MERITON APARTMENTS

131-138 KILLEATON STREET, ST IVES

ACCESSIBILITY REVIEW

30th June 2010

ADAPTABLE
LAYOUT
BLOCK D

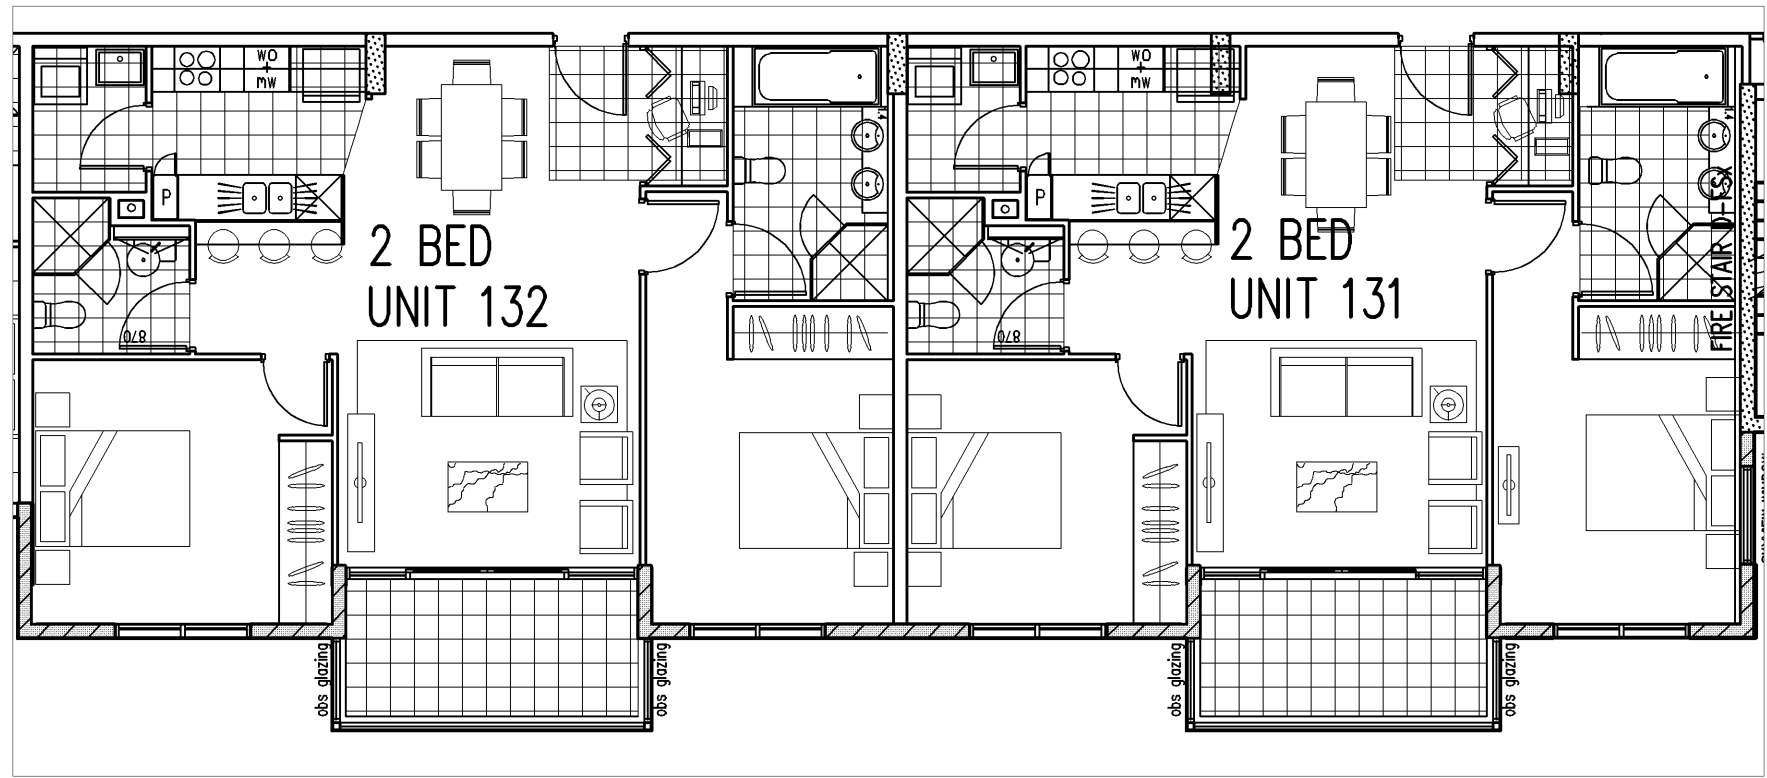
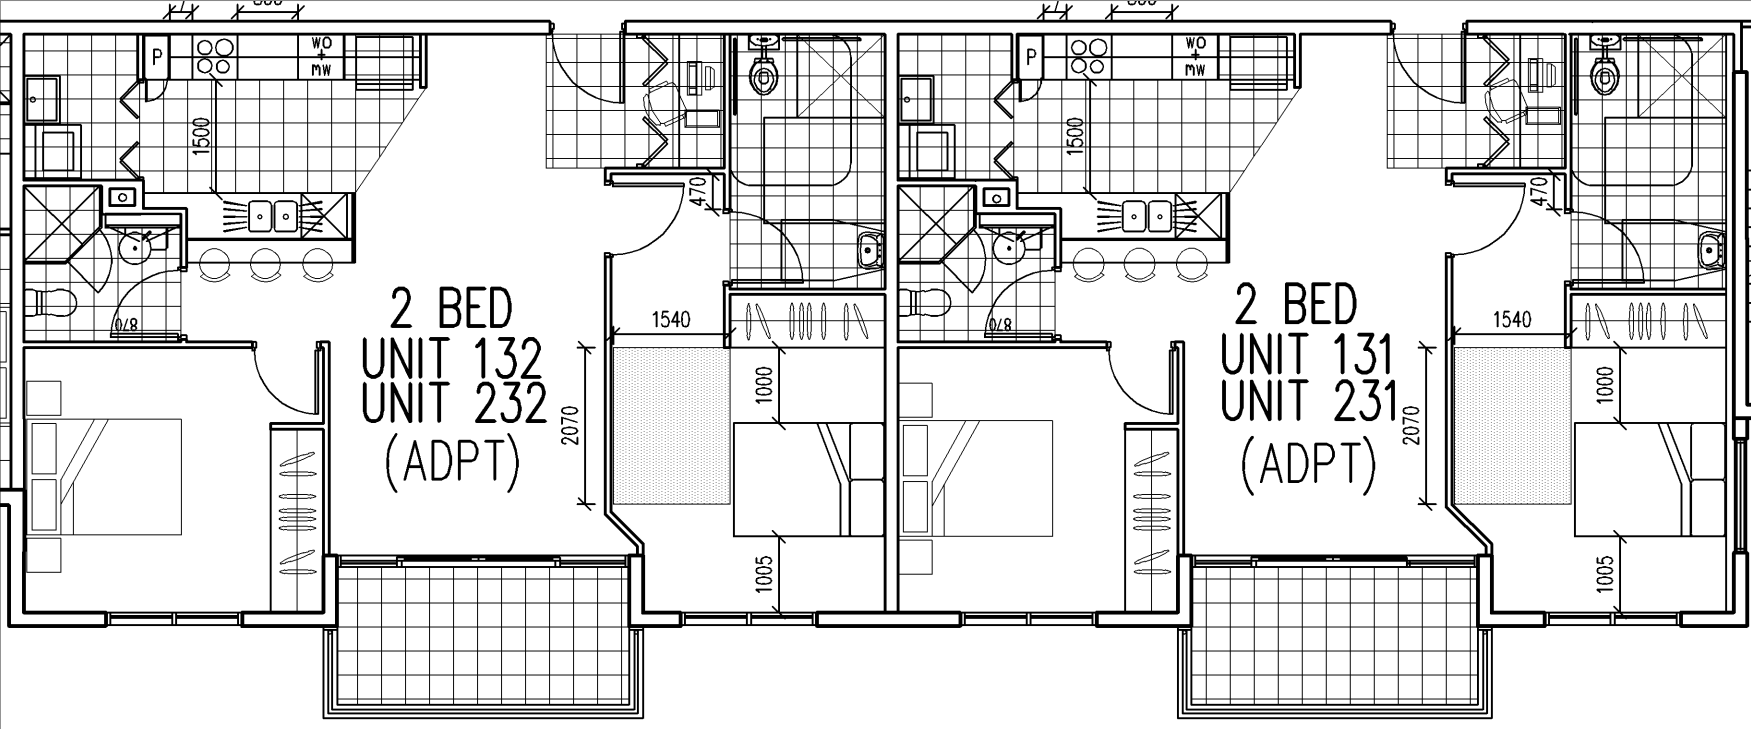
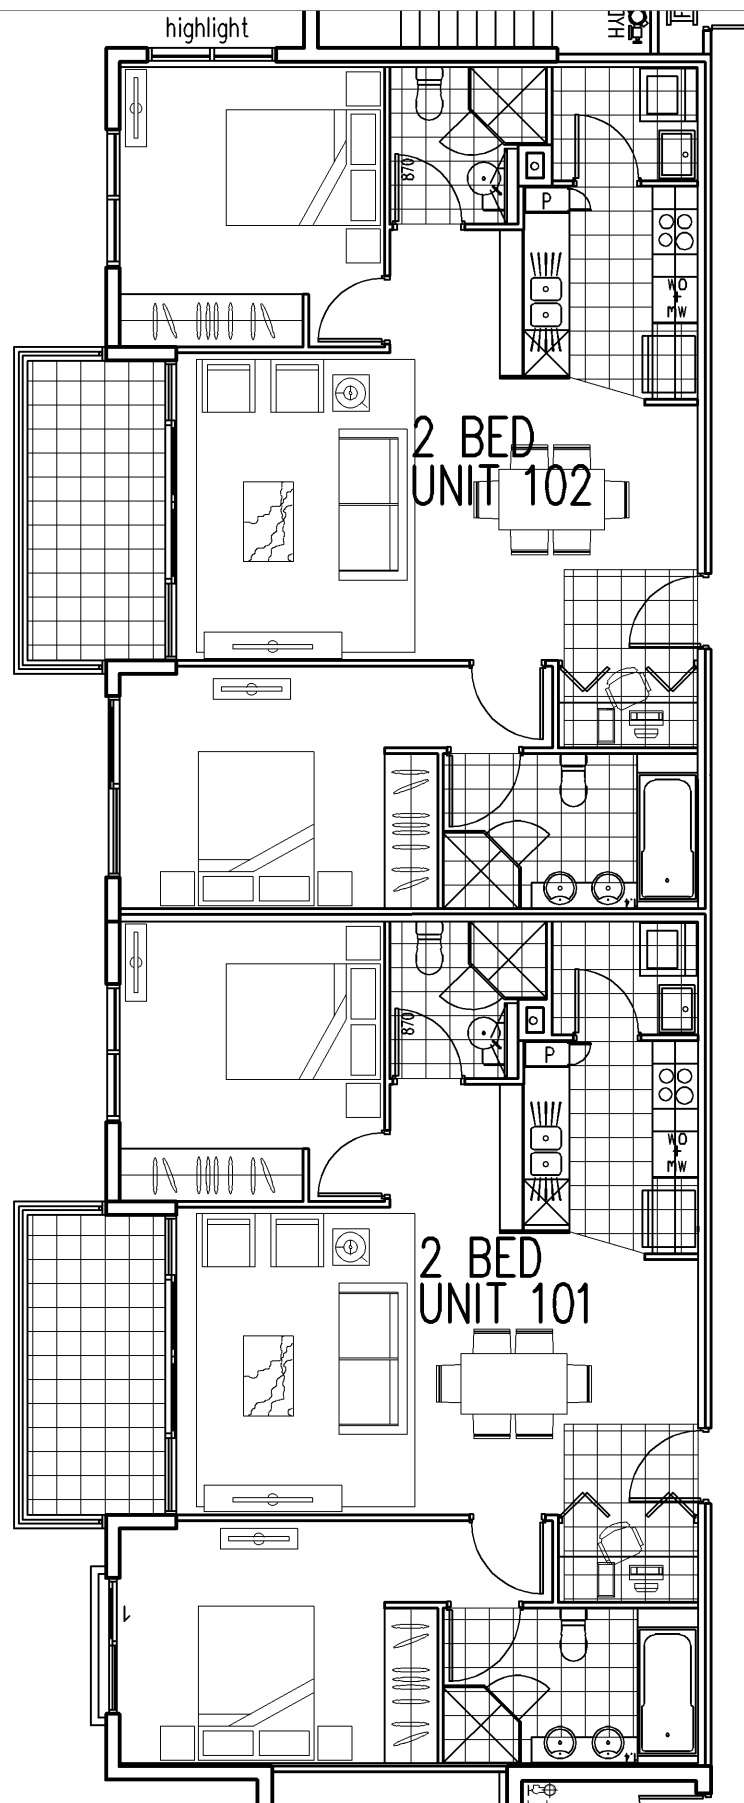
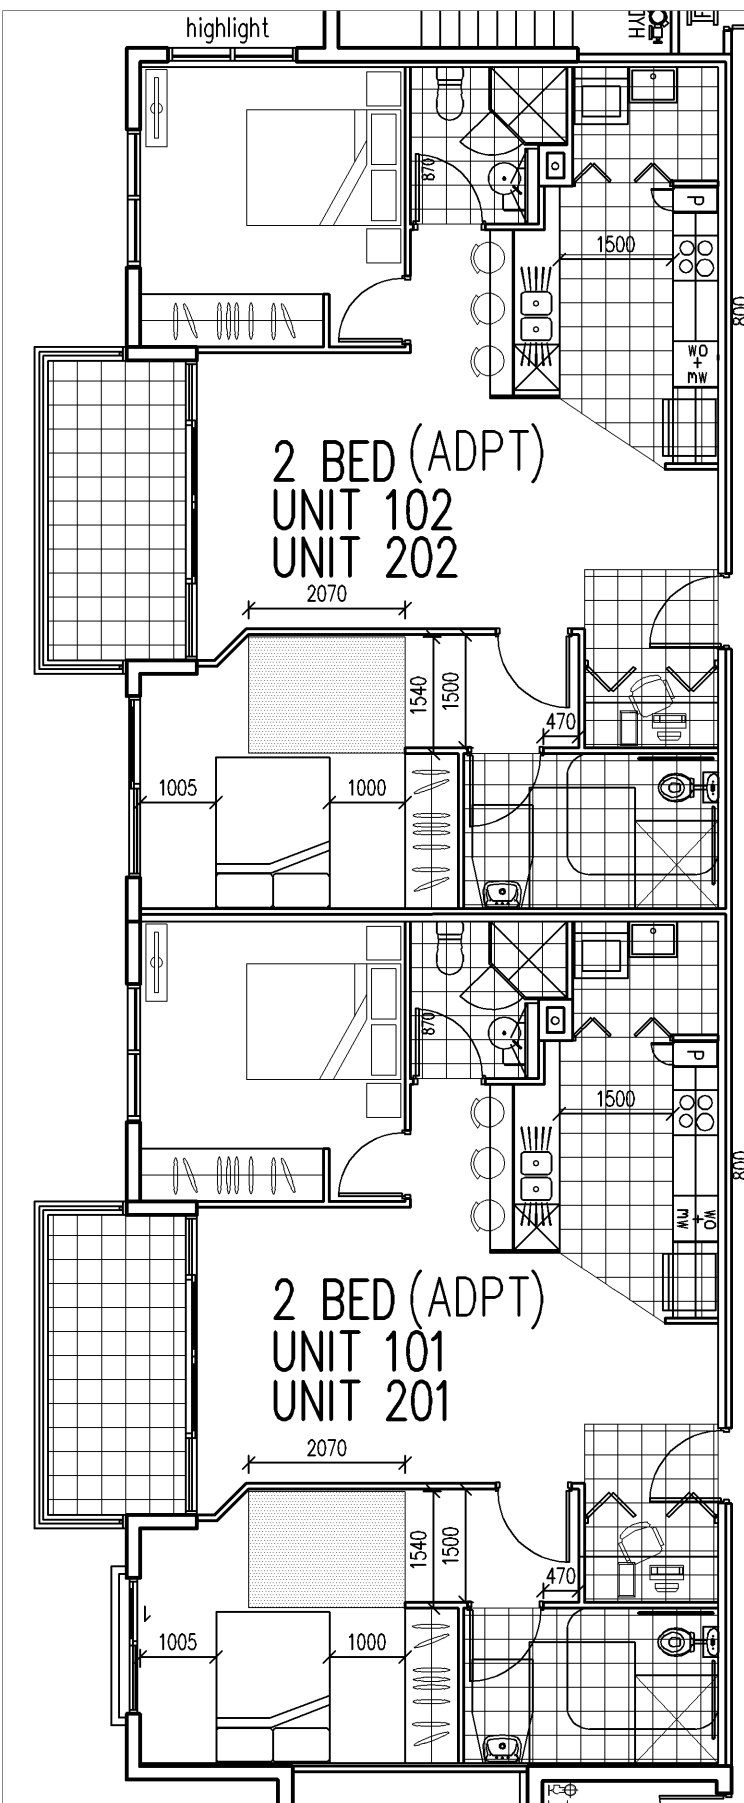
The following recommendations have been made in relation to the typical 2 bed adaptable layout of units 101 and 201 provided.

- i) The bedroom requires internal dimensions of 3600mm x 3600mm, outside the robe area. This will ensure a minimum 1000mm clear width is provided alongside the bed
- ii) Provide separate cook top and wall mounted oven with 800mm long bench between each. Provide a work bench space (800mm in length) adjacent to refrigerator, cook top, wall oven and sink.
- iii) The laundry area (found within the master bathroom) is to have a circulation area in front of the laundry appliances of 1550mm in diameter
